WEST SUSSEX COUNTY COUNCIL CONSULTATION

TO:	Arun District Council FAO: Stuart Corbey
FROM:	WSCC - Highways Authority
DATE:	21 March 2019
LOCATION:	209 Pagham Road Pagham PO21 3QD
SUBJECT:	P/25/19/PD Prior notification under Class M for a change of use from betting shop (Sui Generis) to dwelling house (Class C3).
DATE OF SITE VISIT:	N/A
RECOMMENDATION:	Advice
S106 CONTRIBUTION TOTAL:	N/A

PROJECT: Proposed Change of use with alterations at: Crown Racing, 209 Pagham Road, Pagham PO21 3QD.
DRWG TITLE: PLANNING: As Proposed Plans.
CLIENT: Mr & Mrs S. Markham

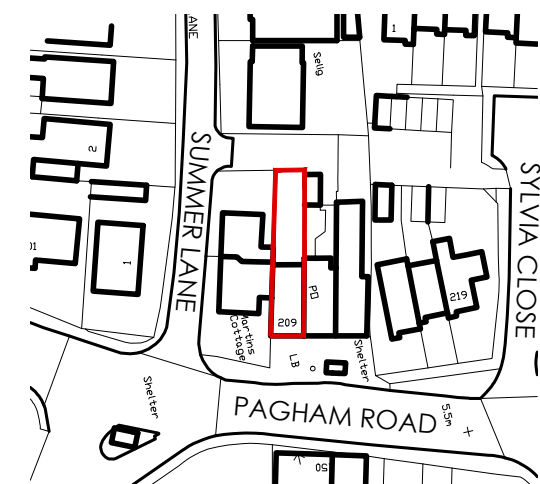
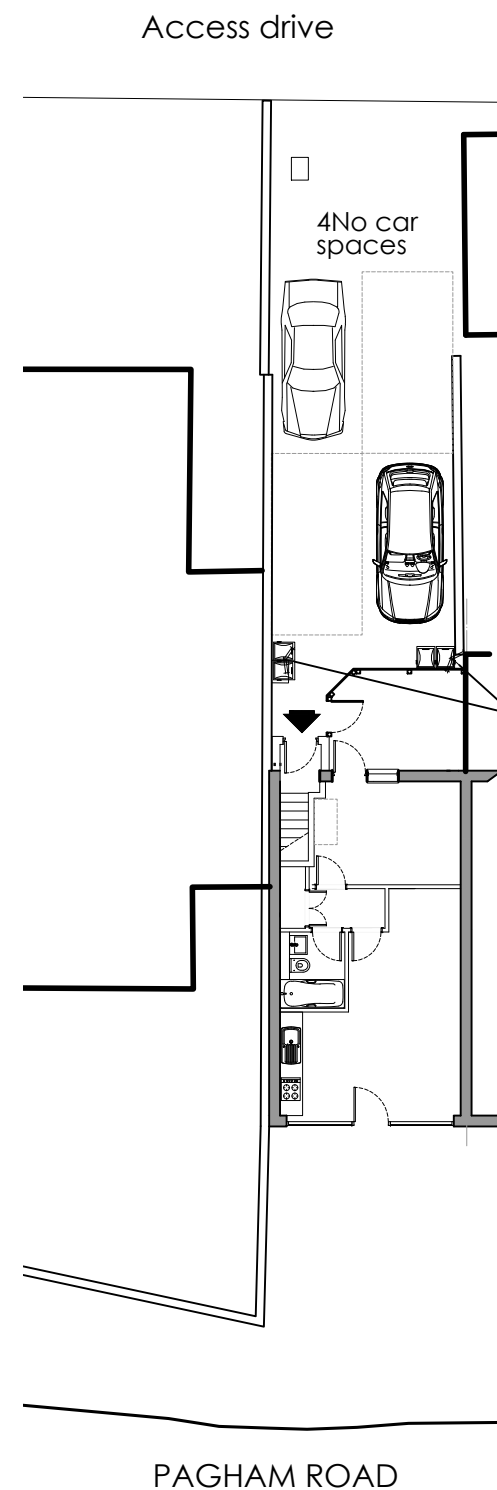
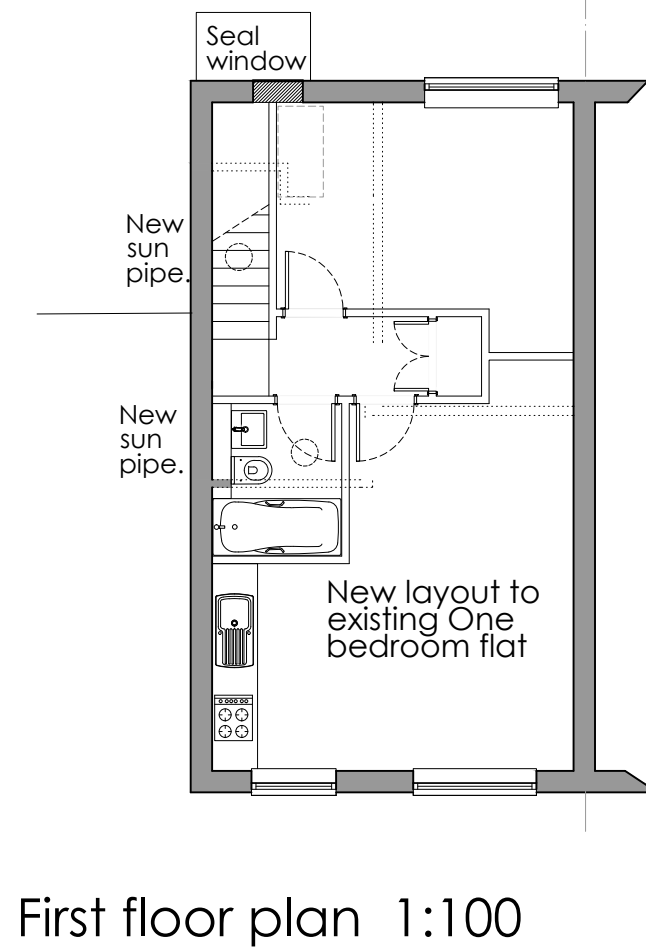
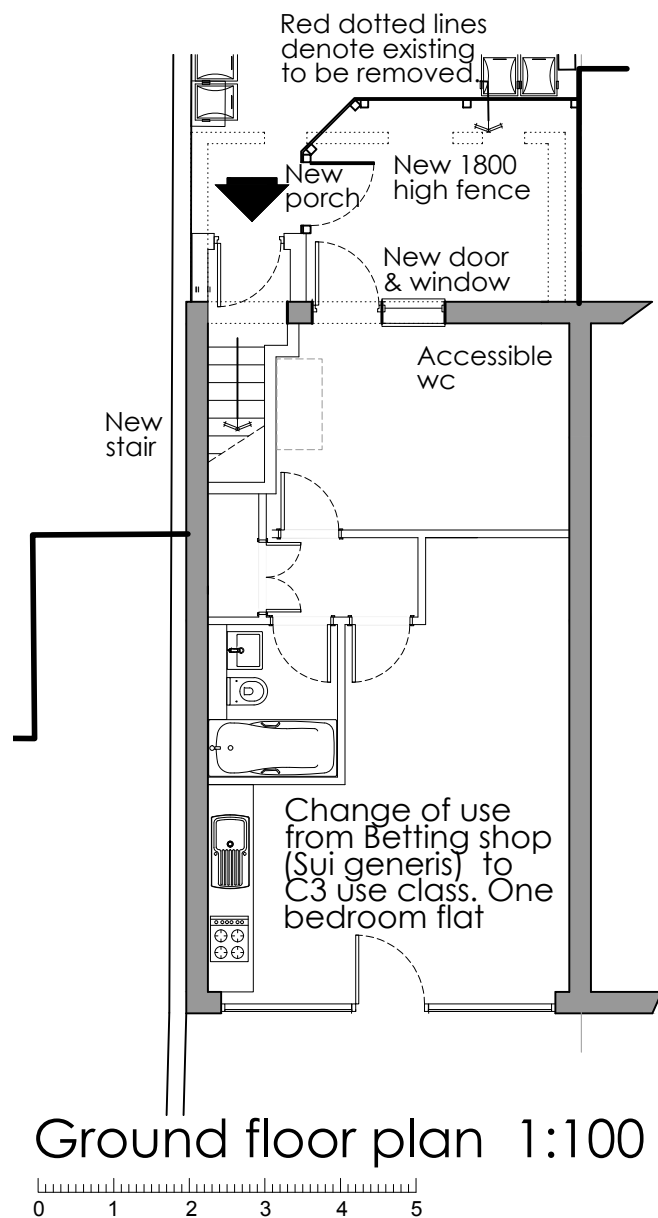
The proposed plans indicate that currently there are four parking spaces to the rear of the site which will be retained for the proposed use. It is unclear whether any of these are allocated to the existing residential use on the first floor of the site. Four parking spaces for a one-bedroom flat exceeds WSCC parking standards for a dwelling of this size and location. The site is located within metres of bus stops and other local shops and services and there is some unrestricted parking in the surrounding vicinity of the site, as such, the LHA anticipate that the level of traffic generated

by this proposal would not result in an increase over the potential traffic generated through the sui generis use.

If the Local Planning Authority is minded to approve the application, they may wish to condition cycle parking.
